Environmental Health Division
1675 W. Garden of the Gods Road
Suite 2044
Colorado Springs, CO 80907
(719) 578-3199 *phone*
(719) 578-3188 *fax*
www.elpasocountyhealth.org

Cathedral Pines Filing 3, Lot 20 Amendment, VR-17-008

Please accept the following comments from El Paso County Public Health for the vacation replat request referenced above:

**CATHEDRAL PINES SUBDIVISION FILING NO. 3C**

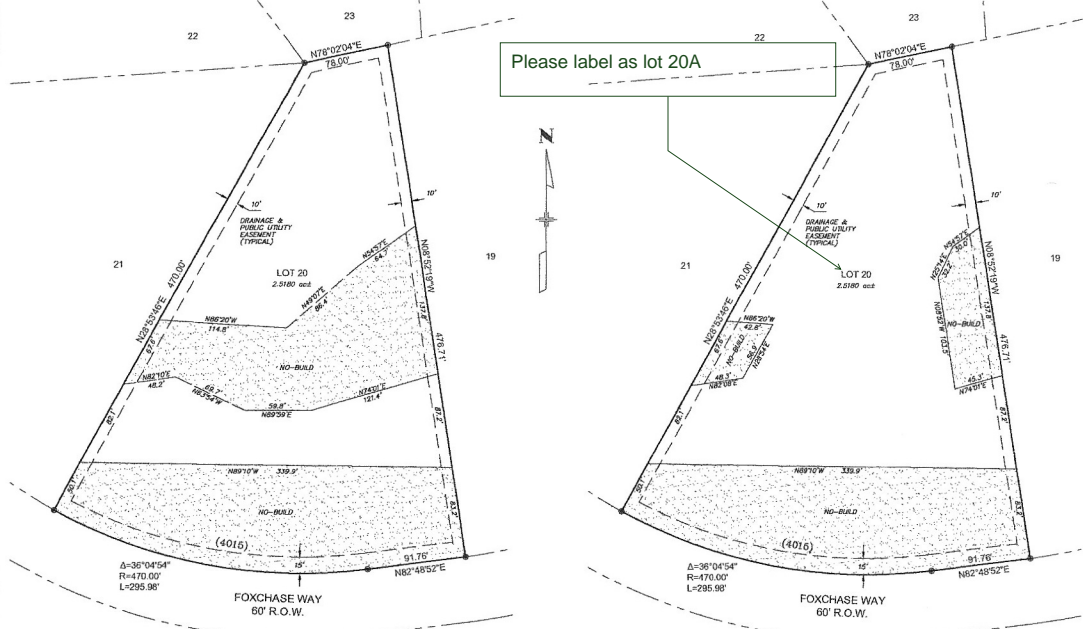
- **El Paso County Public Health supports the proposed reduction of the 30% slope, no build zone on Lot 20. The increased amount of “buildable area” improves the ability of the property owner to better locate both primary and secondary sites for the onsite wastewater treatment system (OWTS), soil treatment area (STA), and to locate a private well and maintain minimum horizontal setbacks for all the OWTS components.**

**LOT 20
SITEPLAN**

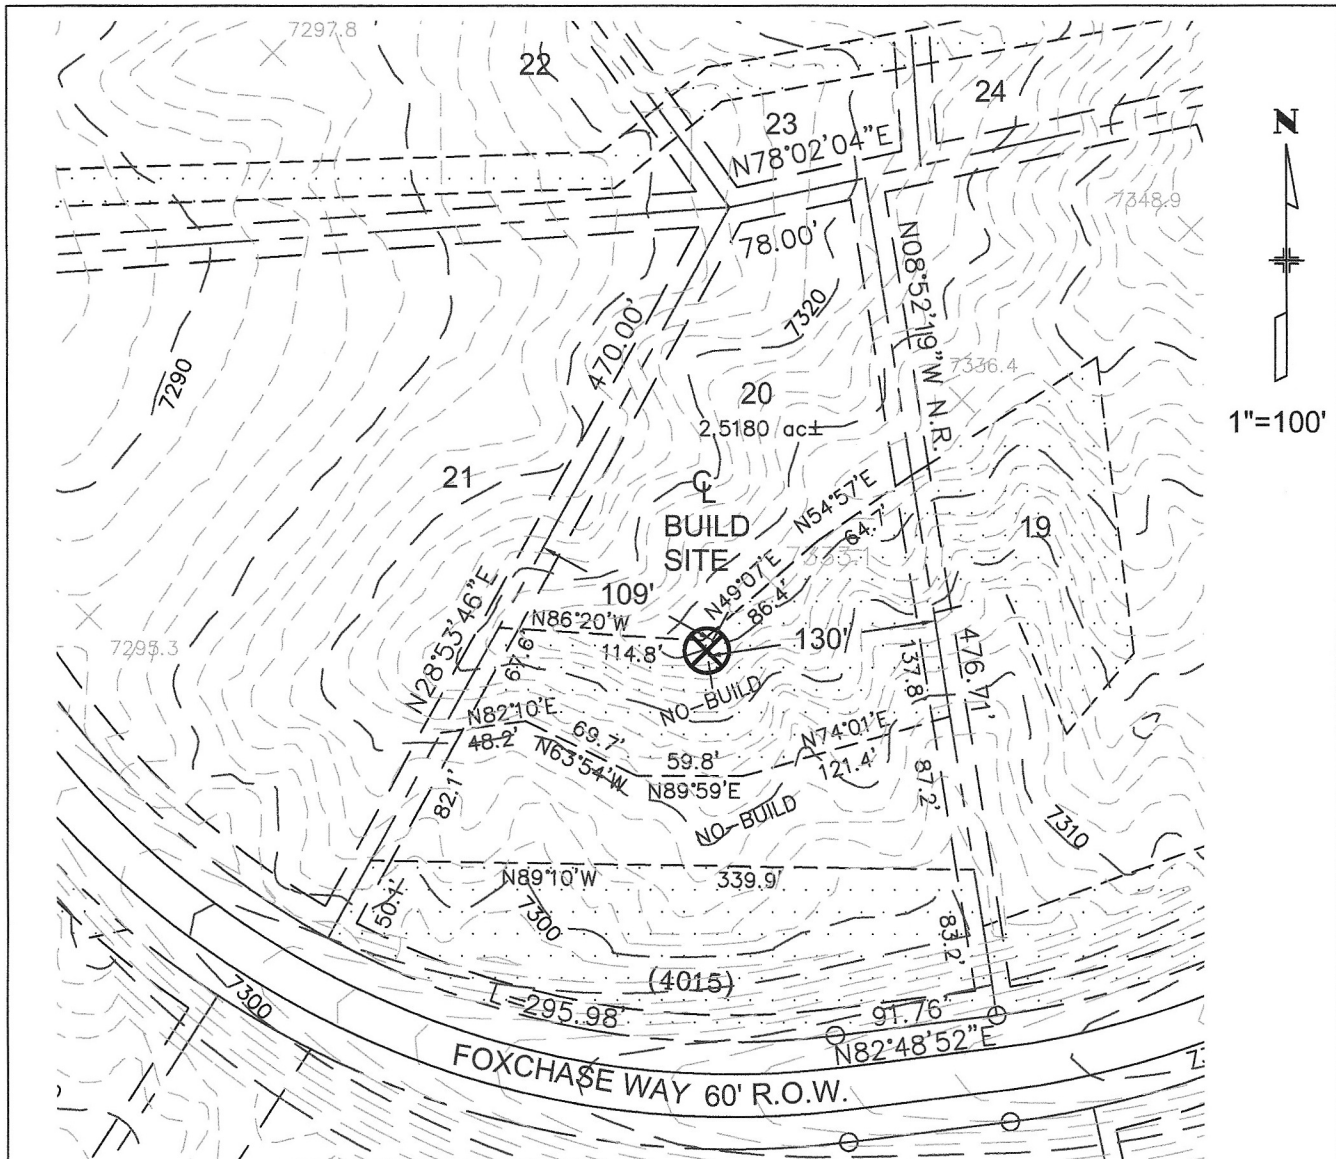
- **As noted in the 10Aug2017 letter from Red River Civil Engineering, Inc., and the LWA Land Surveying, Inc., site plan, erosion control best management practices should be used on the site to protect the development site and neighboring properties until the site is re-stabilized with vegetation.**
